Our Ref: 497DA228 (11/908) STH08/01370
Contact: Andrea Boes 4221 2771
Your Ref: MP06_0209 MOD 3

**WOLLONGONG CITY COUNCIL – MP06_0209 MODIFICATION 3 – KEIRA STREET,
WOLLONGONG PROPOSED MIXED USE DEVELOPMENT**

Reference is made to the RTA's letter dated 18 August 2011 regarding the subject development application.

SECTION THROUGH EASTERN KEIRA STREET FOOTPATH
SCALE 1:250

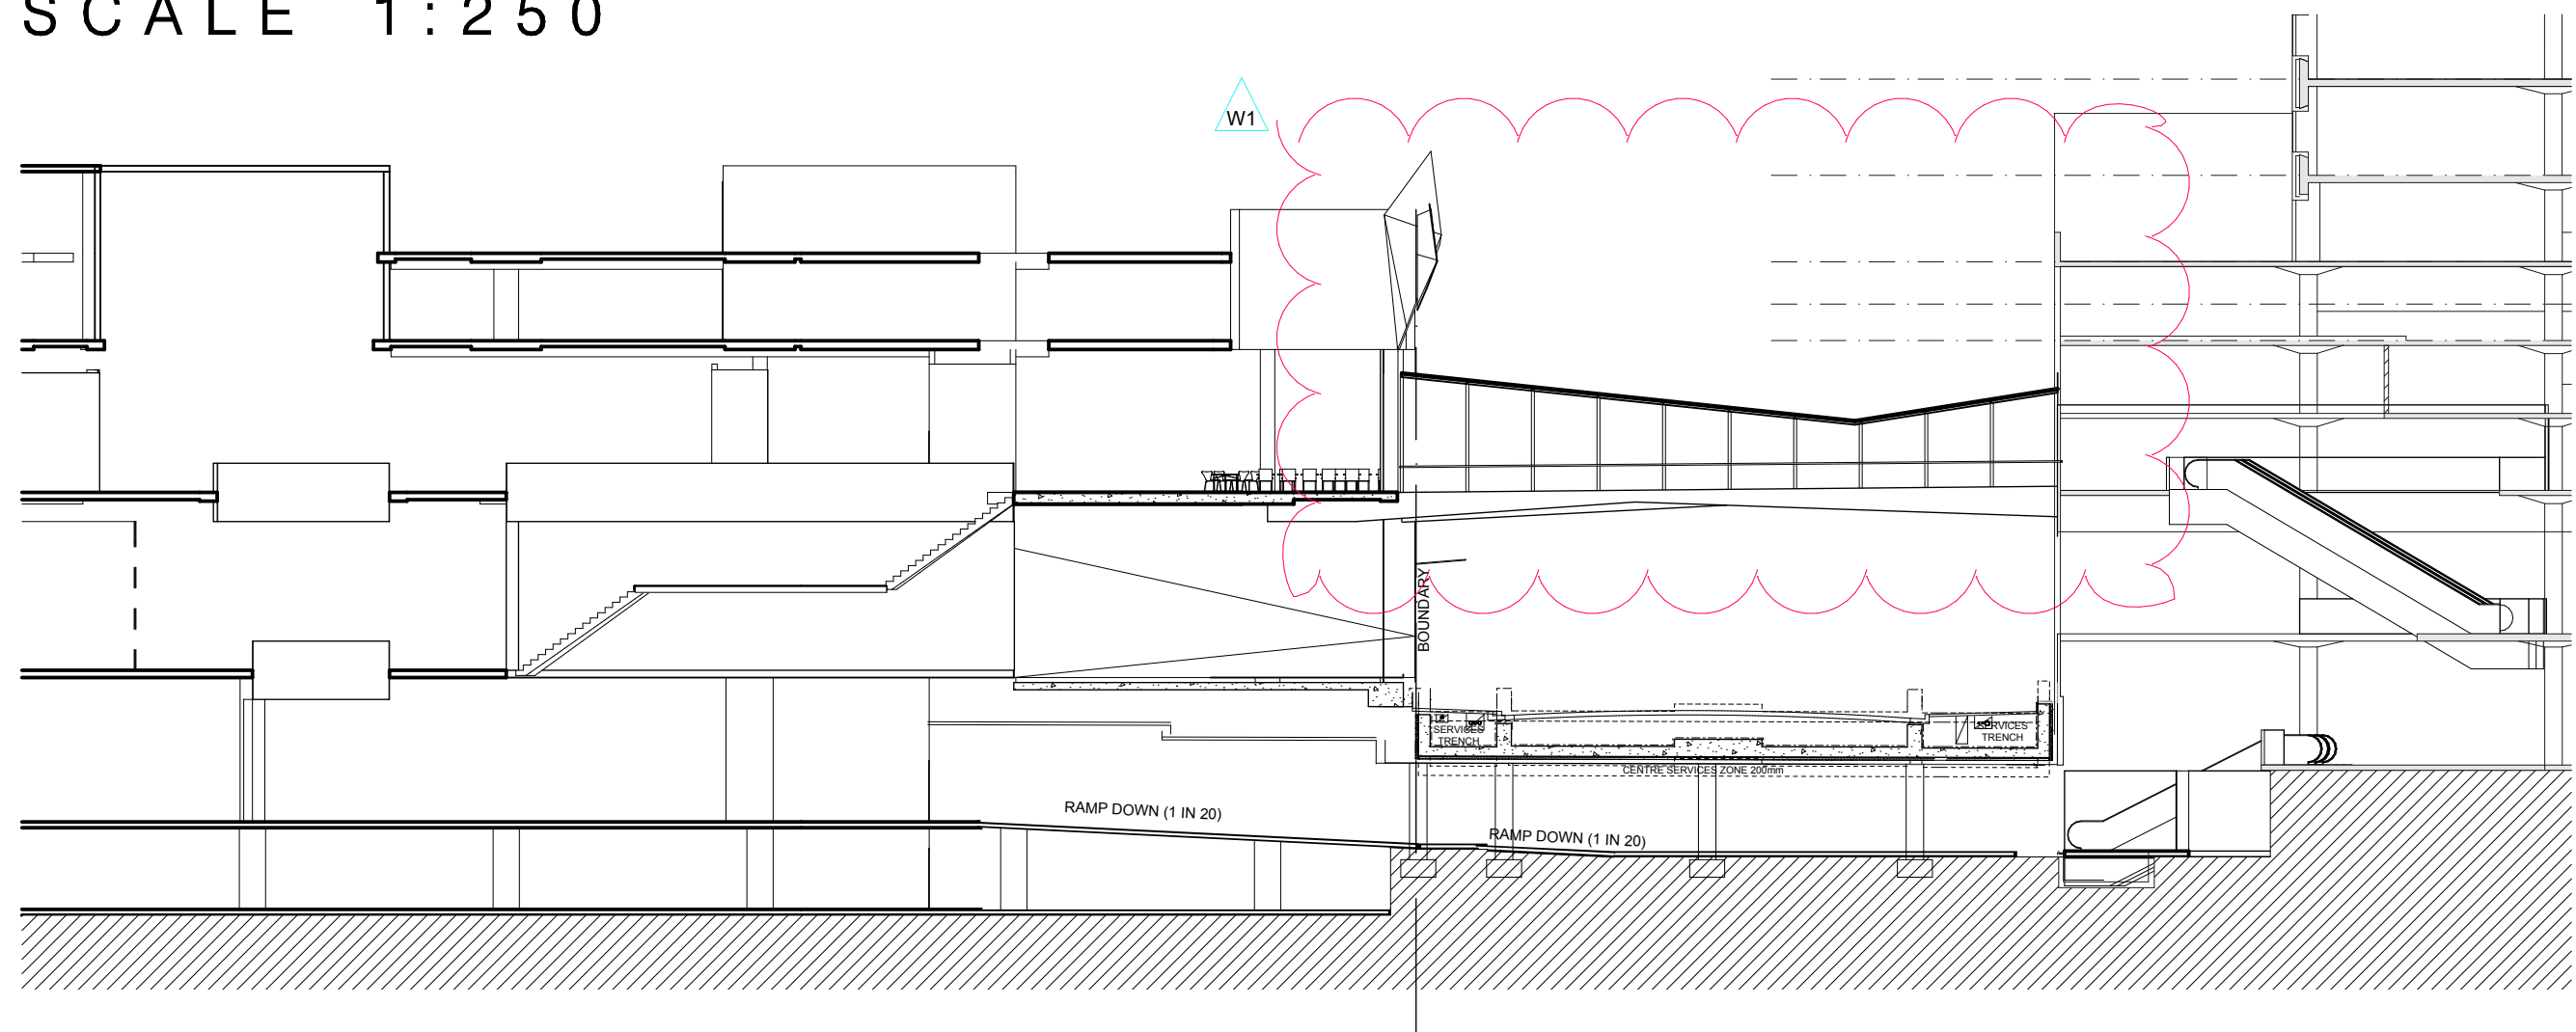
The RTA has reconsidered its position in relation to the location of the bus shelter and footpath with respect to the kerb and gutter and GPT Building Façade. In this regard, the RTA's position was stated that "the bus shelters are to be located adjacent to the kerb with a pedestrian footpath of suitable width between the shelters and the building façade." Following further consideration of this matter, the RTA recognises that this arrangement may not be the most appropriate at this location and that it may be more appropriate to locate the bus shelter adjacent to building façade in order to improve the amenity of the area for both pedestrians and bus passengers. This may in turn have a positive impact on the use of the facility and bus mode share generally.

Given the above, the RTA is willing to consider locating bus shelters adjacent to the building façade provide that there is sufficient footpath width provided for through pedestrians. If you have any questions, please contact Andrea Boes on 4221 2771.
